Advice on Environmental Impact Statement – State Significant Development

Proposal: Molong Battery Energy Storage System

Major Project reference: SSD-80471210

Attachment A – Detailed Aboriginal cultural heritage advice

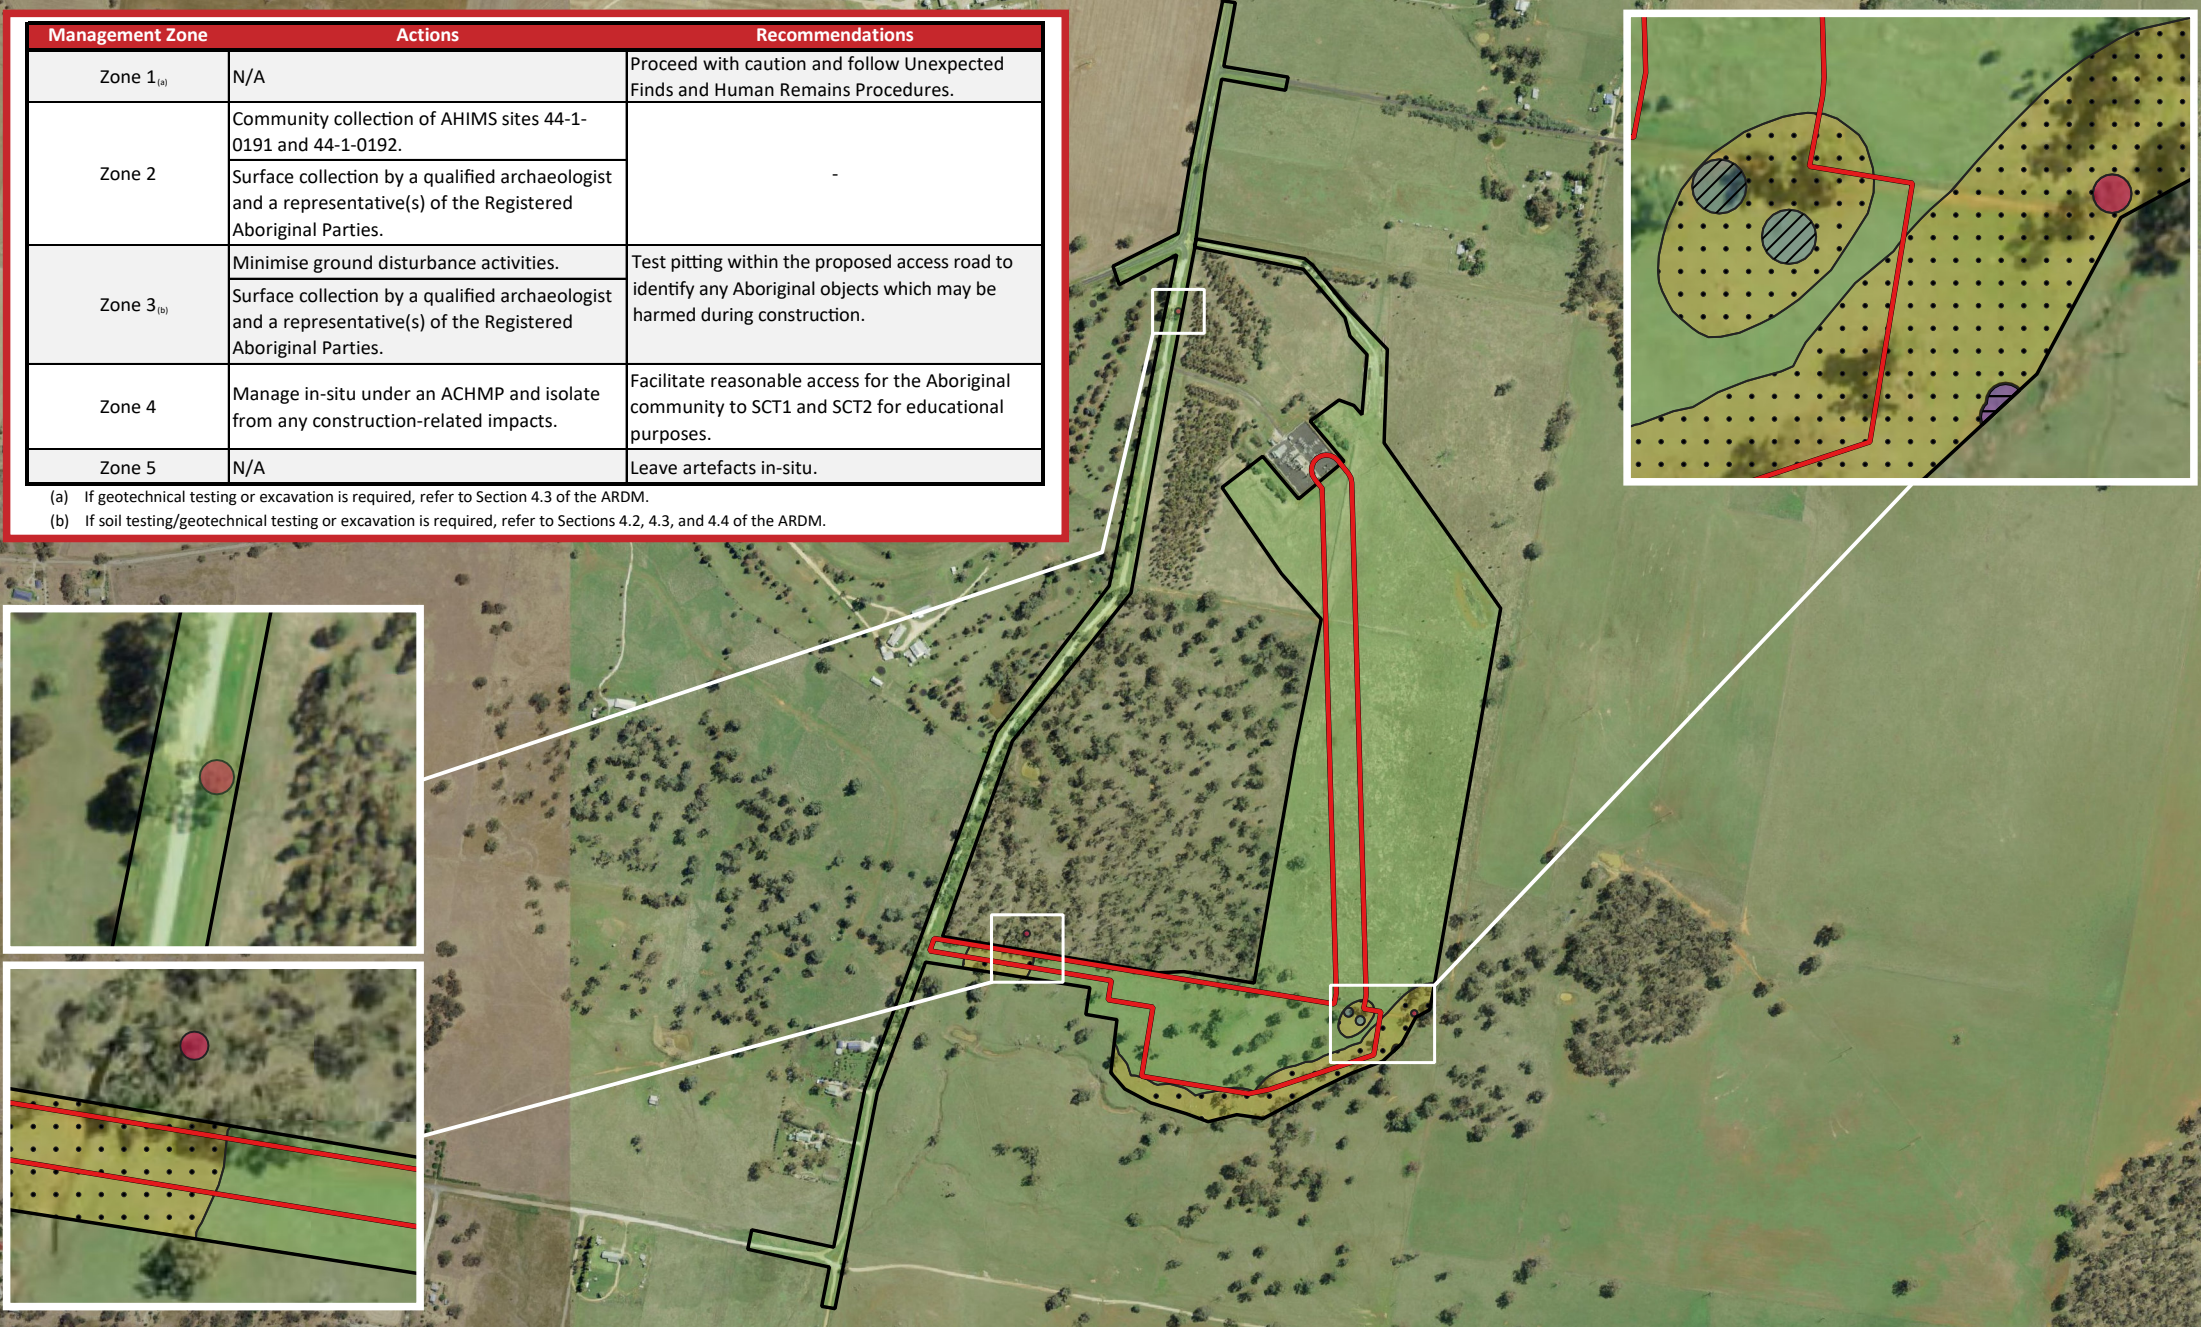
8. Figure 3 in Appendix C of the Archaeological Assessment does not include the area of moderate sensitivity associated with AHIMS 44-1-0191 / Molong Grinding Stone and AHIMS 44-1-0192 / Molong IF2 or associated management measures. Please update this figure and associated management measures to reflect the recommendations of the assessment.
9. The ACHA refers to the requirement for an Aboriginal Heritage Impact Permit (AHIP) for the proposed works. Please note that as the project is being assessed as an SSD, an AHIP would not be required to allow the proposed works to proceed should the SSD proposal be approved.
